***MODIFICATION REQUEST:  
Stages 2 and 3, Site 3 Mixed Use  
Development  
Australia Avenue, Sydney Olympic Park  
(MP 10\_0027 MOD 1)***

***Modifications to Tower 1 floor layouts***

Director-General's  
Environmental Assessment Report  
Section 75W of the  
*Environmental Planning and Assessment Act 1979*

July 2012

Site 3
Sydney Olympic Park
Plan
Level 19-21

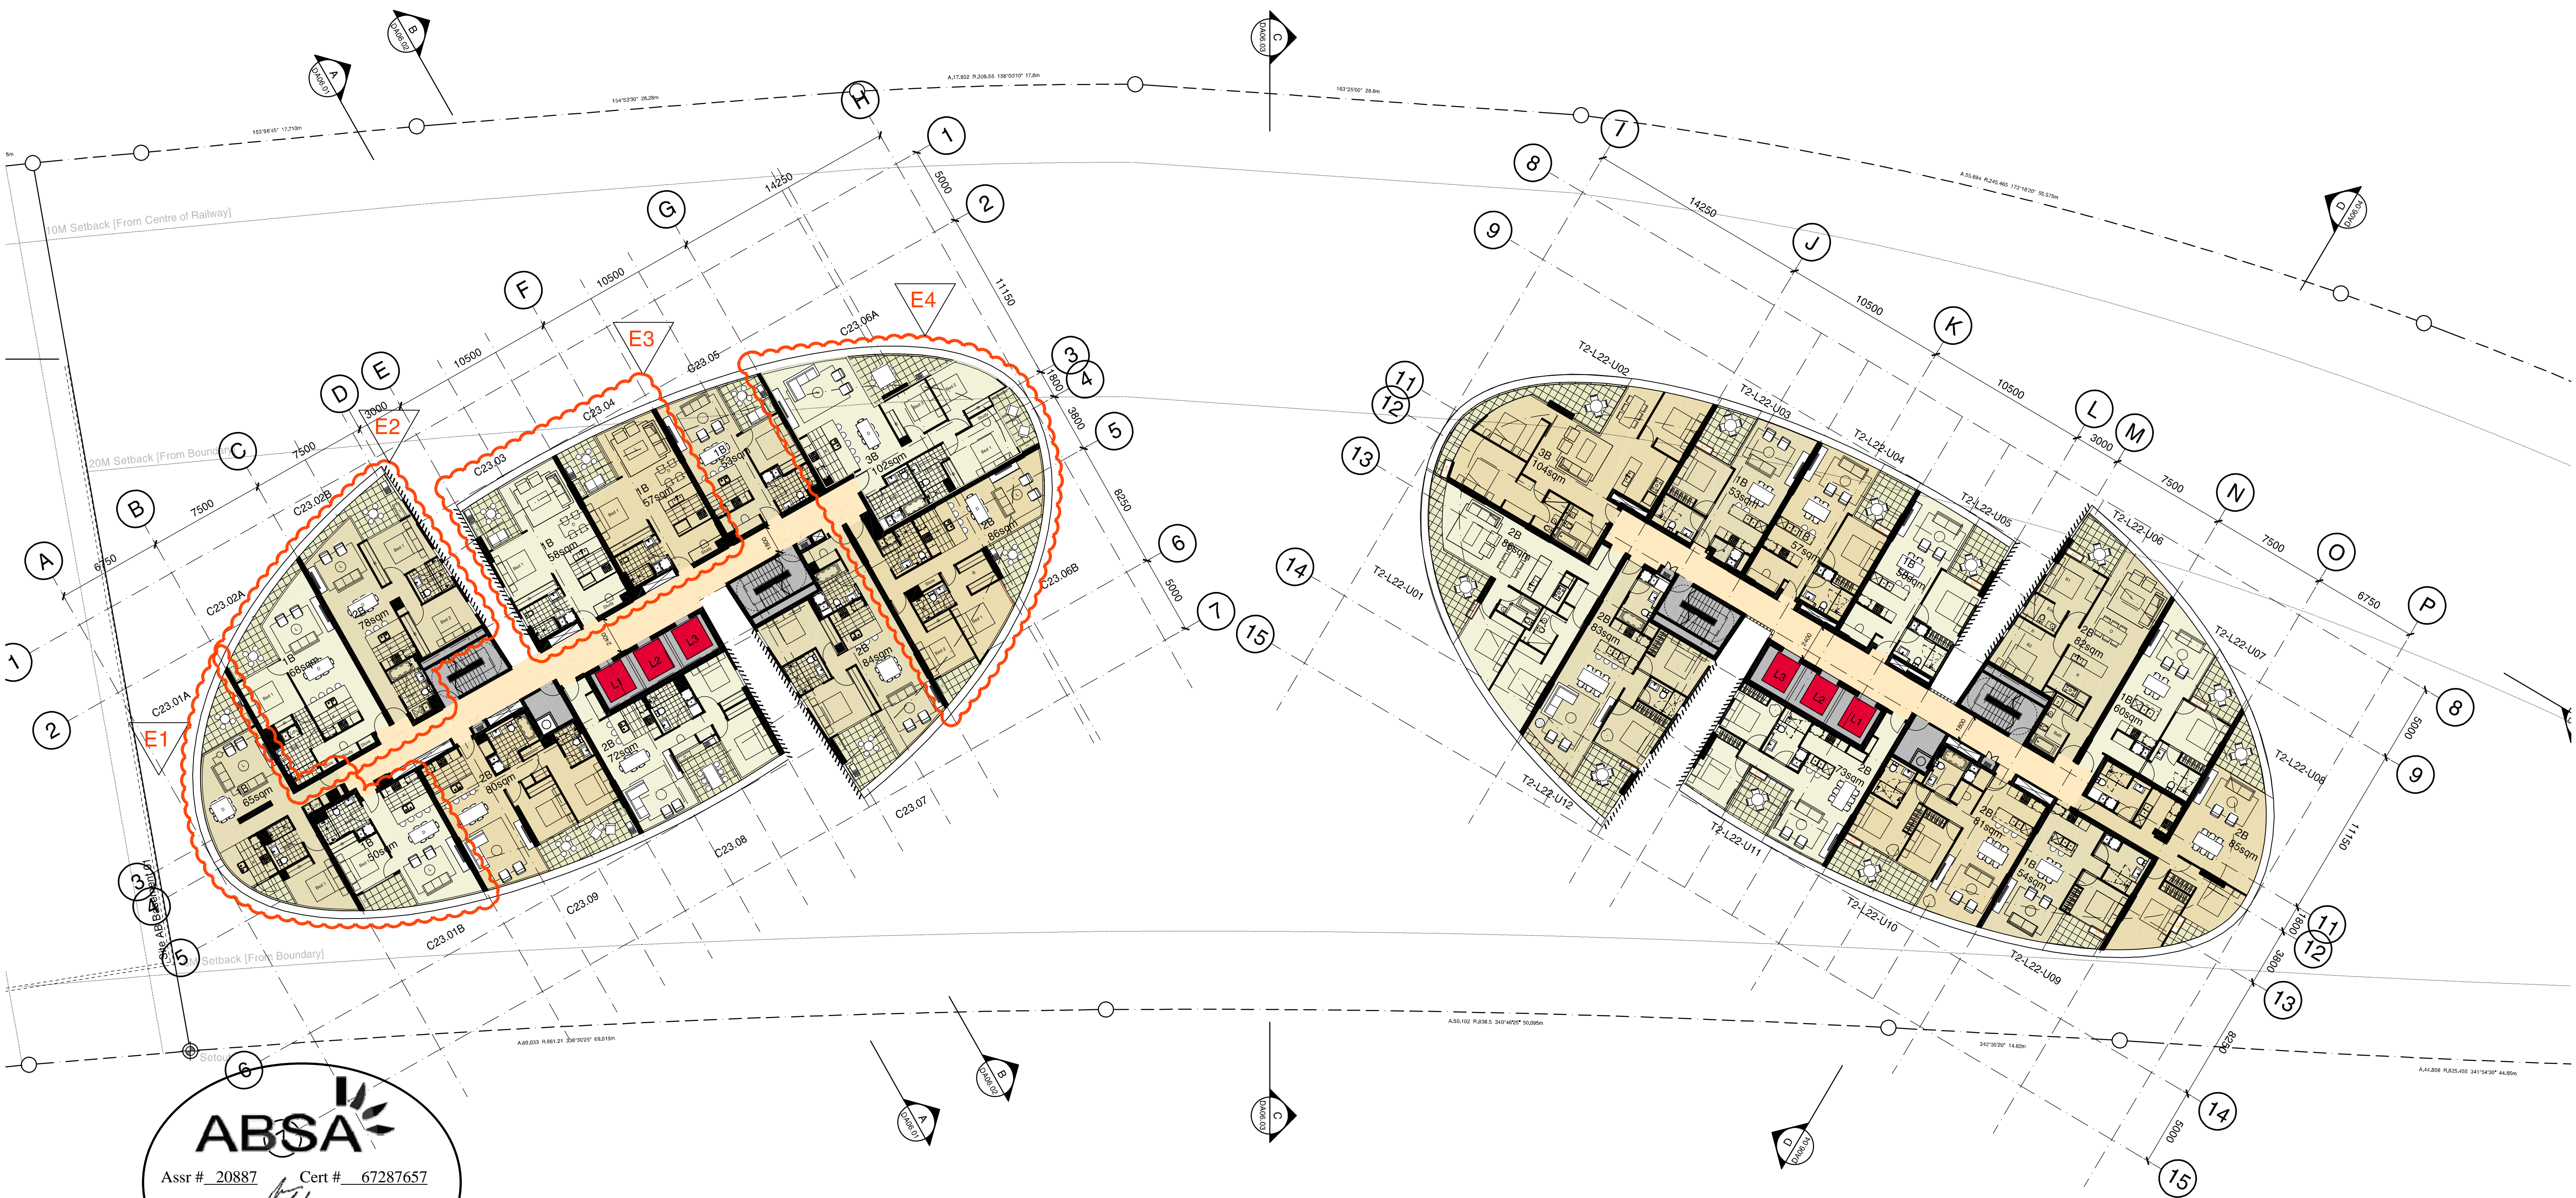
SOPA raised concerns regarding the ability of the modified proposal to achieve adequate levels of cross-ventilation and the functionality of some of the new balconies given their small size. The proponent has demonstrated that the units in Tower 1 and Tower 2 meet the minimum 60 per cent of units required in the RFDC to be cross-ventilated. Whilst SOPA identified the size of some of the new balconies (see Figure 9) as being dysfunctional due to their size, the department considers that they are acceptable as they are secondary balconies and the primary balconies meet RFDC guidelines. Furthermore, balconies of a similar size and design were previously included in the design of units within both the towers (see Figure 10) and were considered consistent with the RFDC guidelines, which promote the provision of secondary balconies.

Figure 9: Proposed floor plan for levels 19-21

Accordingly, the department considers that as the modifications are essentially internal reconfigurations and that the overall compliance with the RFDC can be maintained, the amenity impacts are minimal and acceptable.

1 North Elevation - Tower 1
1:250

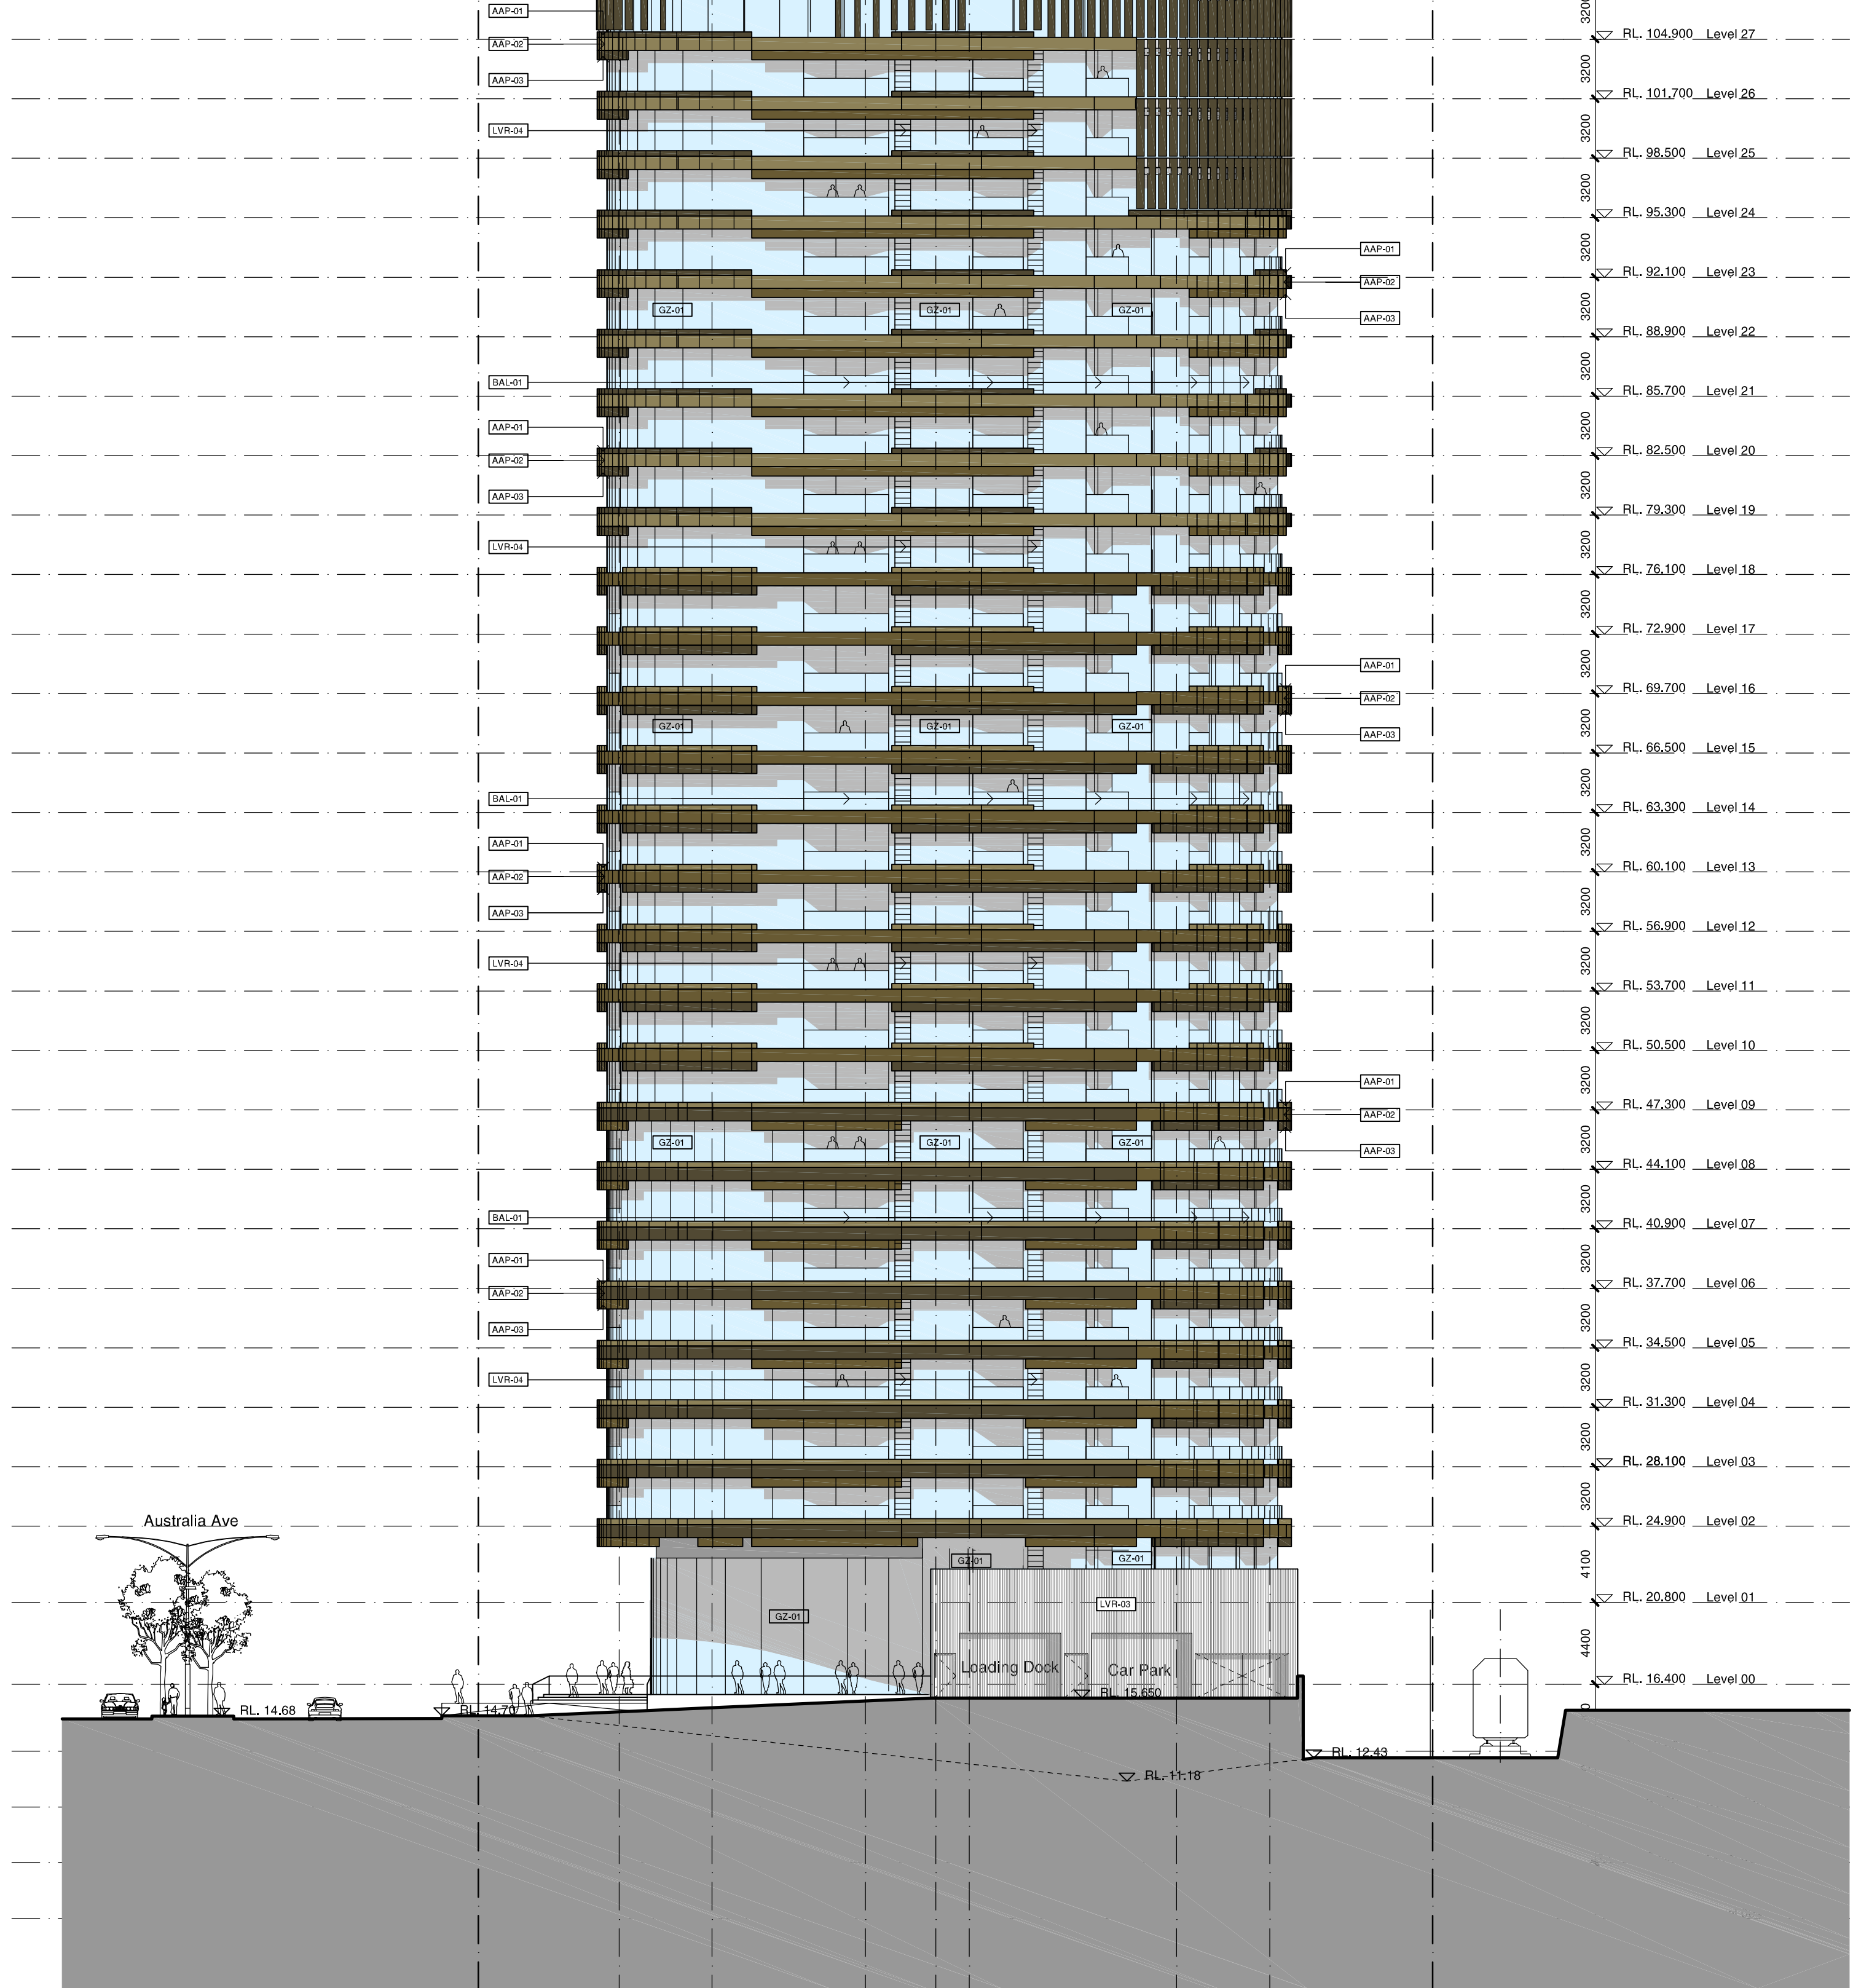
The proposal modifies the layout of the upper levels of Tower 1 to increase the number of one and two bedroom apartments. Whilst there would be an increase in gross floor area (GFA) by 52 sqm as a result of reduction in some corridor space, slightly smaller balconies for some units, and infilling the voids at Level 24, the bulk and scale of the tower would remain generally the same. The appearance of the building will change as a result of the modified articulation with revised balconies, windows and materials due to the modified unit layouts. The amendments would be generally imperceptible from most views to the building and the balustrades and glazing elements would remain relatively unaltered along the elevations (see Figures 1-8).
